From: Dourte, Richard H.
Sent: Tuesday, September 28, 2010 9:44 AM
To: Cherne, Curtis ; Sims, Timothy E.
Cc: 'chuck@energy-associates.com'
Subject: (12808 Piru SE)

*Drainage Report
for*

*Tijeras Heights
Subdivision*

Bruno Conegliano
Asst. City Engineer-Hydrology

Goldberg · Mann & Associates Engineers-Planners 911 Pennsylvania N.E. Albuquerque, New Mexico 87110	NO.	DATE	BY	REVISIONS	DESIGNED BY: S.C.	JOB NO. 0813	ENERDYNE CORPORATION TIJERAS HEIGHTS SUBDIVISION	DRAINAGE PLAN	FILE NO.
					DRAWN BY: B.G.	DATE: MAY 1978			FIGURE 4
					APPROVED: T.M.

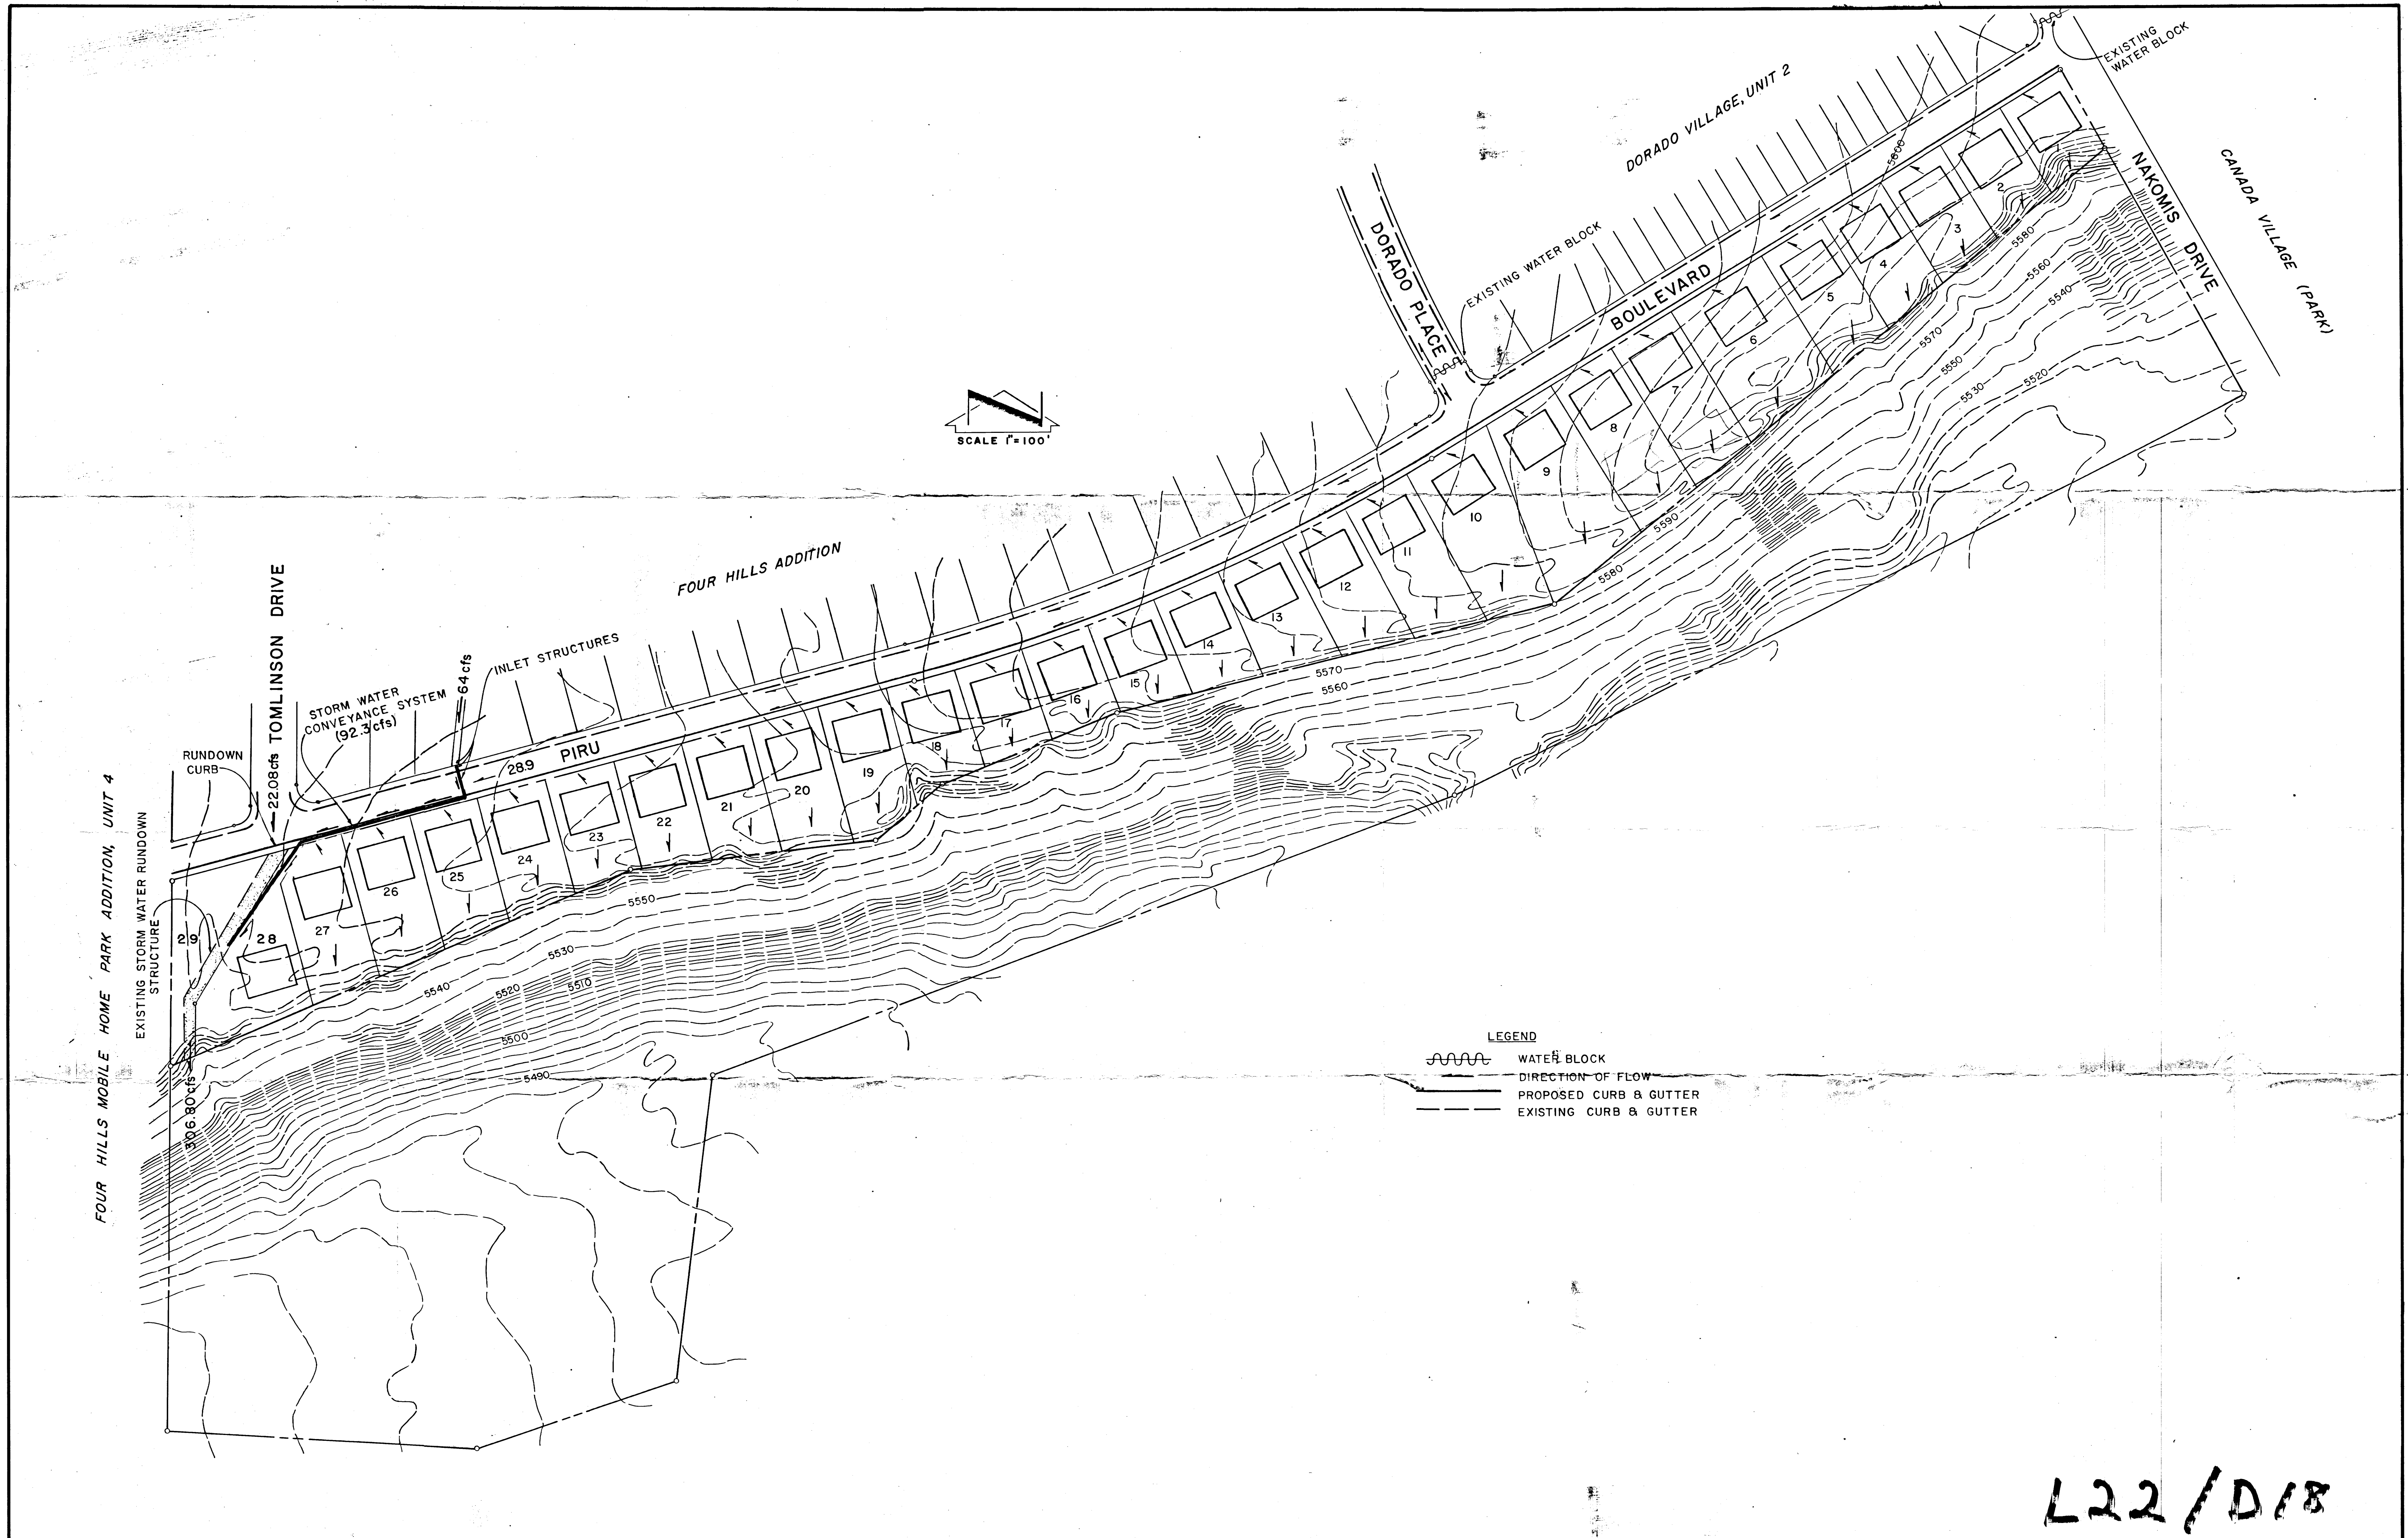
The drainage provision for Tijeras Heights Subdivision are generally acceptable except for the recommendation of allowing the runoff from the rear lots to flow over the embankment and directly into the Tijeras Arroyo. The discharge of the runoff into the Arroyo is not objectionable in itself, rather the possibility of gullying and erosion of the steep bank. For instance as shown on Figure 4 of the drainage report Lots 1,2,5,6 & 18 appear to be particularly susceptible to damages. I would therefore like to receive an addendum indicating a positive method of control of the potential erosion problem.

Please define also the status of the southern part of the property which covers the slope of the Tijeras Canyon Arroyo and part of the channel.

1. A note will be placed on the final plat stating -
"All front yards and roofs shall drain to Piru Blvd.
and drainage from rear yards shall not form a concentrated discharge but shall remain as sheet flow when draining to the arroyo".
2. The developer will not dedicate the flood plain to AMAFCA at this time.
3. The developer intends to retain the bank of the arroyo as open space.
4. AMAFCA concurs with the drainage plan as submitted and modified herein.
